DECISION DELEGATED TO HEAD OF PLANNING

Application No: H14-0450-22 **Applicant:** P N Holdings Ltd.

Proposal: Residential Development - Erection of Dwelling (re-submission of H14-0811-21)

Location: Adj. 47 Milestone Lane Pinchbeck Spalding

DRAWING TITLE
SUNLIGHT AND DAYLIGHT PLANS

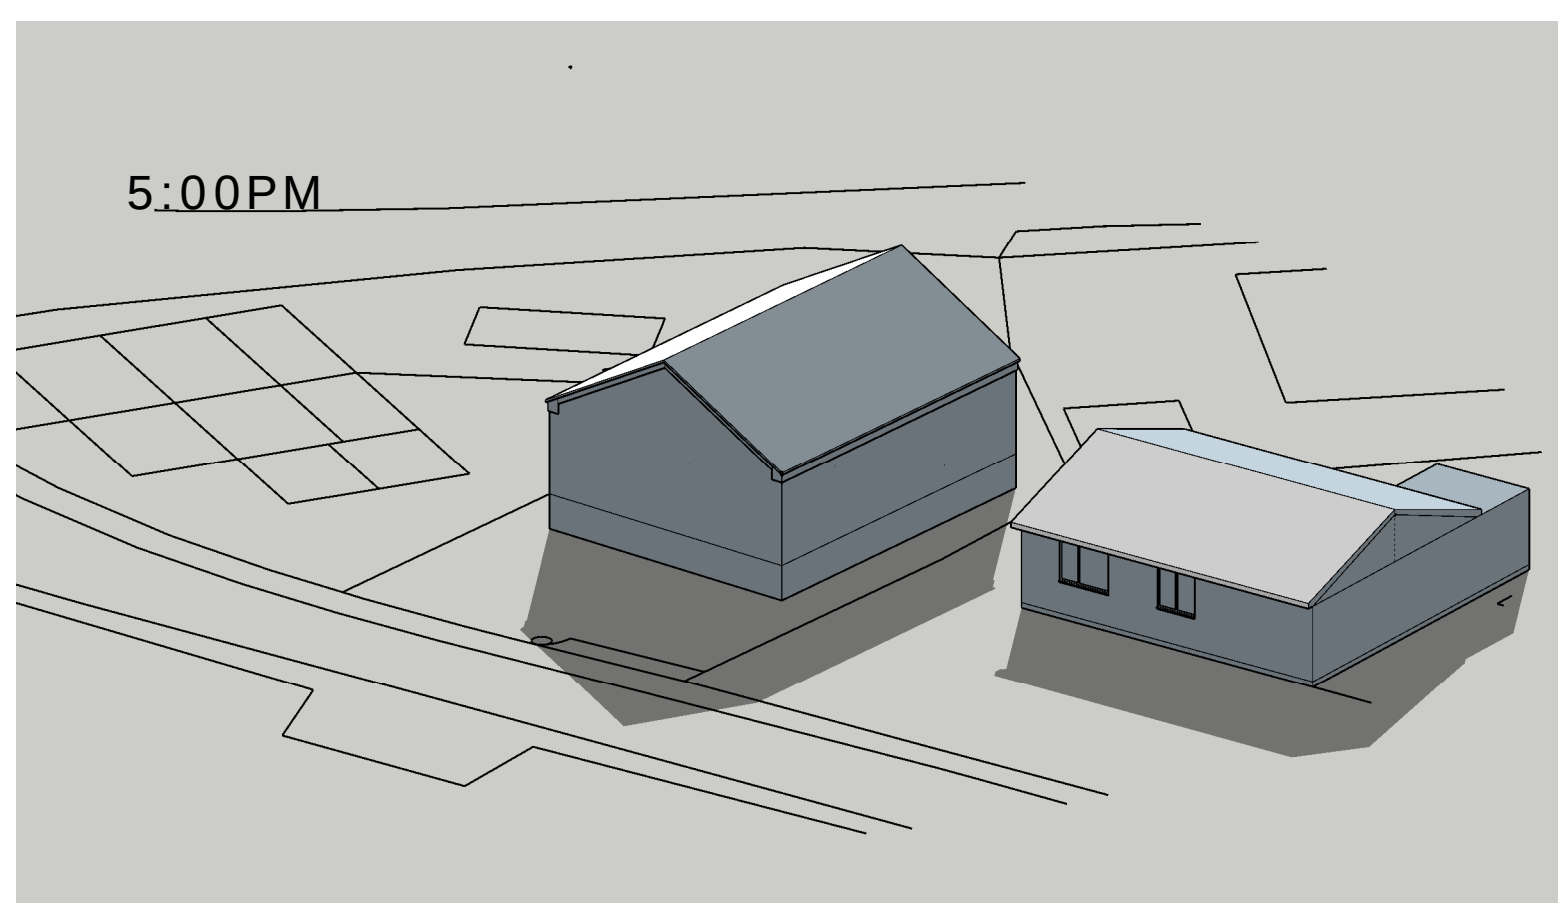
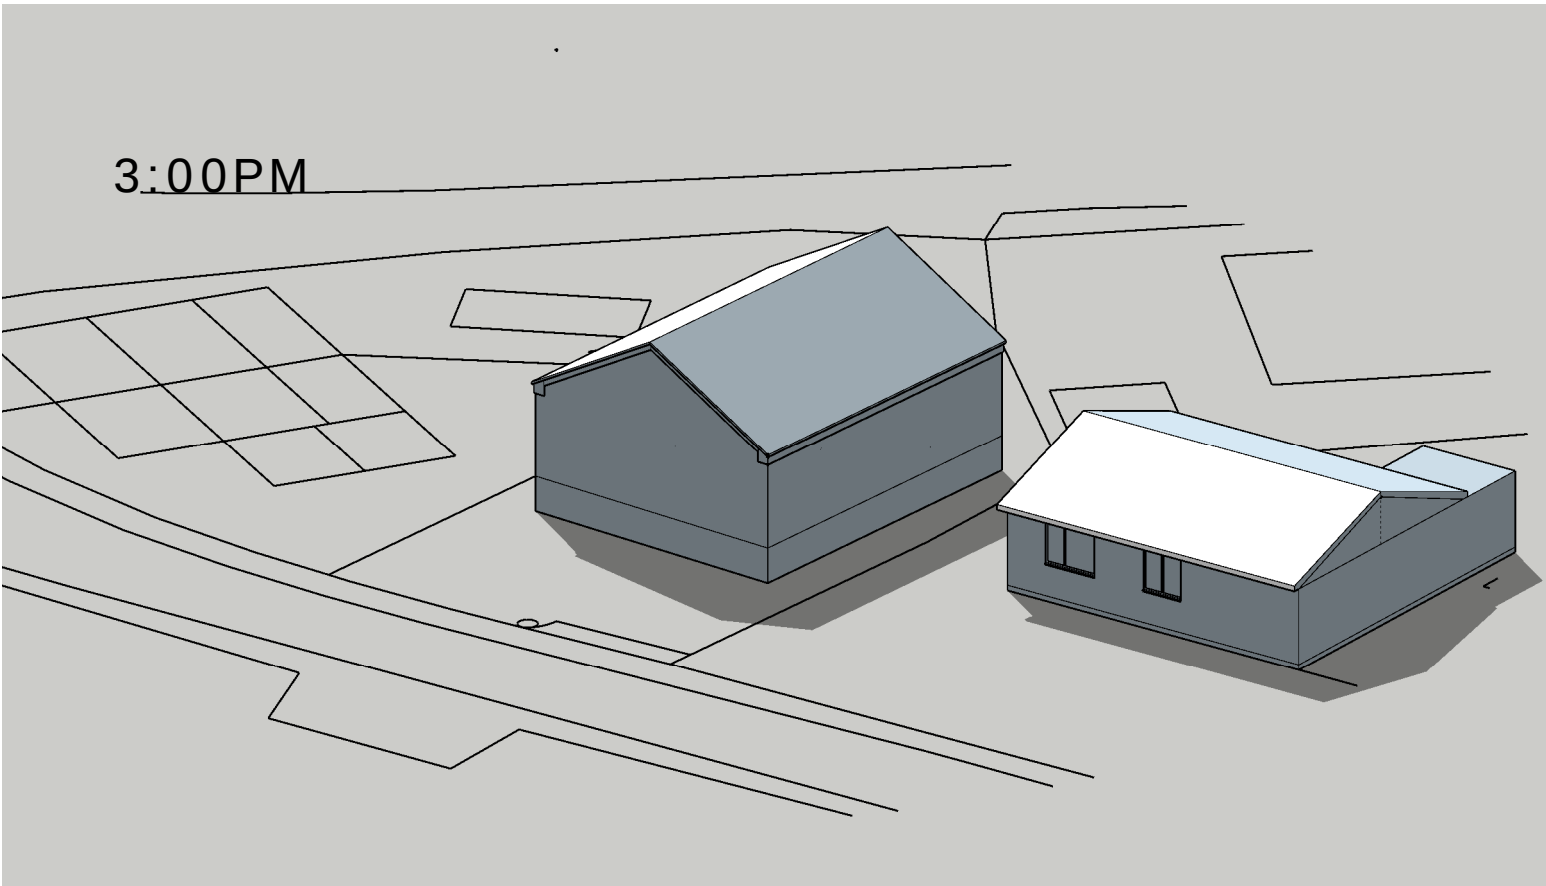
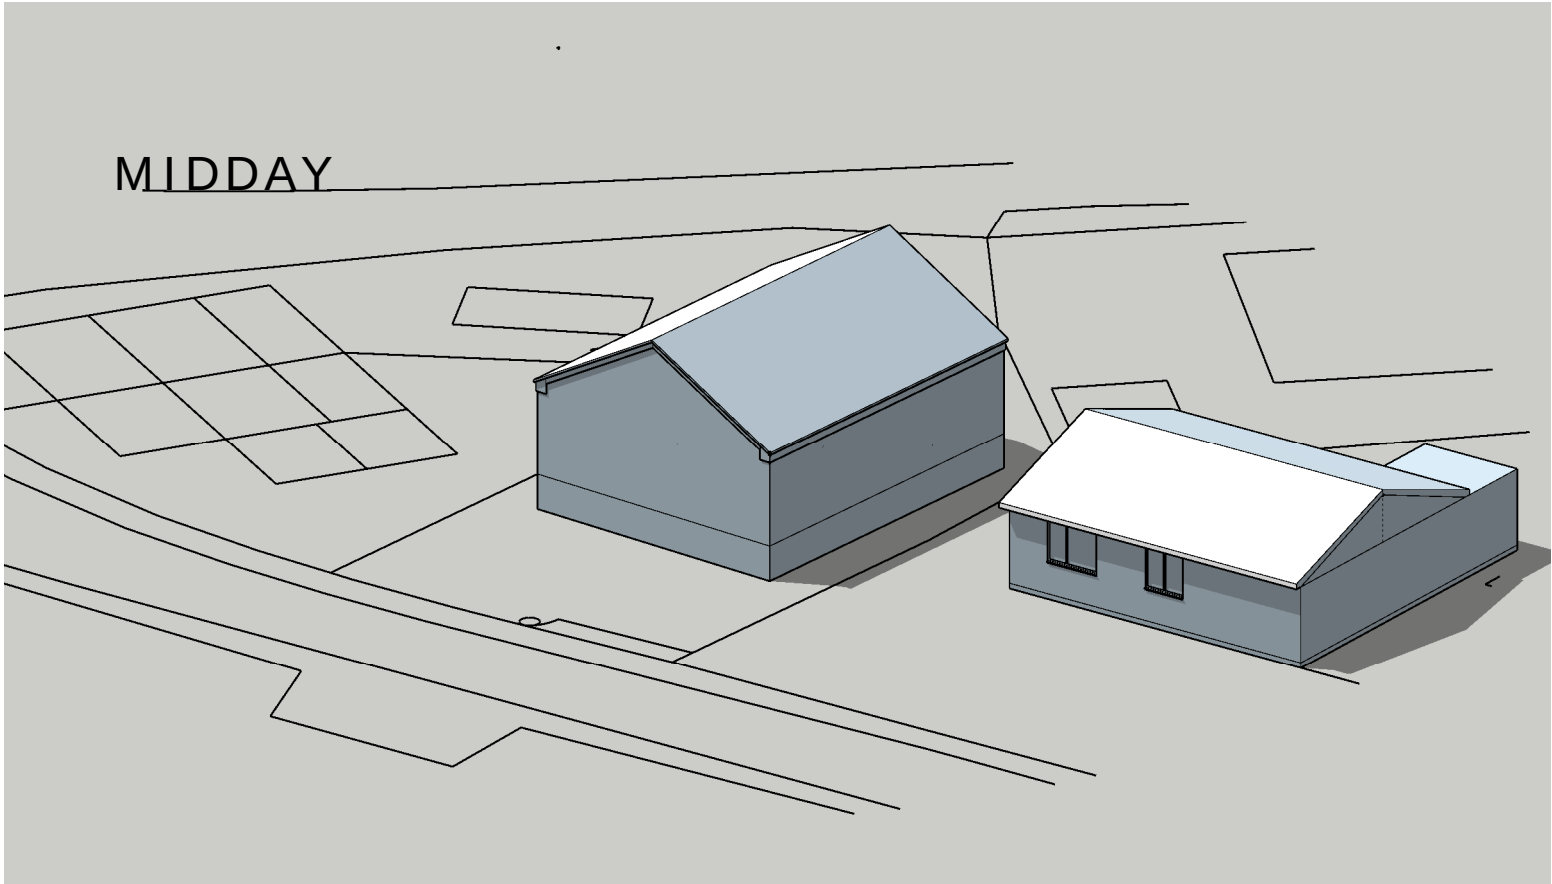
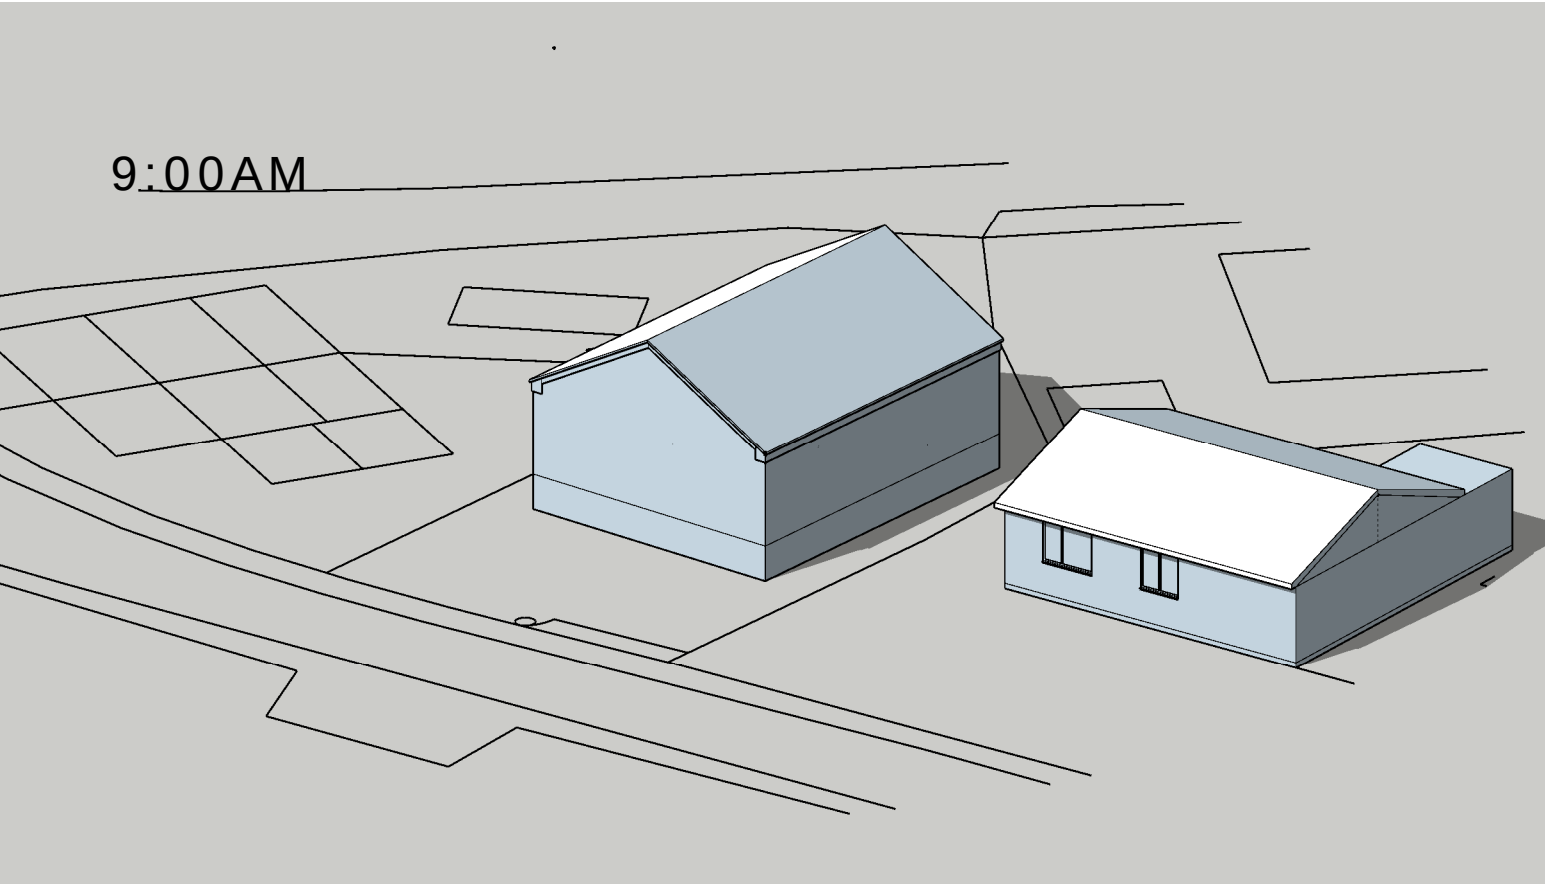
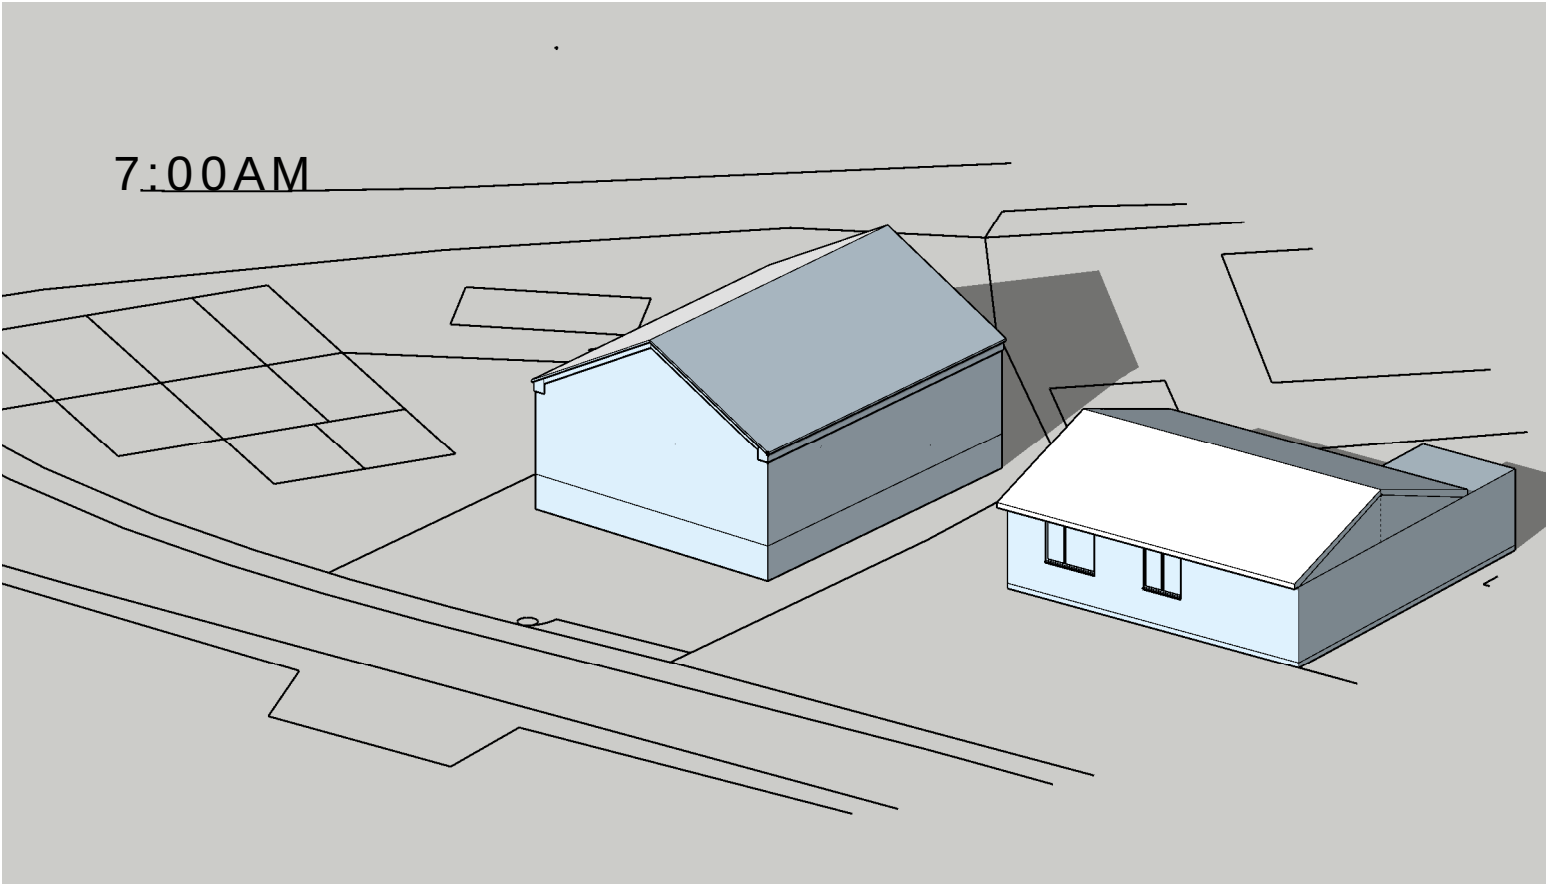
Concerns have also been raised regarding overshadowing. Given that further evidence has been provided that the proposed dwelling would not have an adverse impact on daylight/sunlight levels to the property to the north, the Local Planning Authority is unable to determine whether the impact of the proposed development on this property would be acceptable.
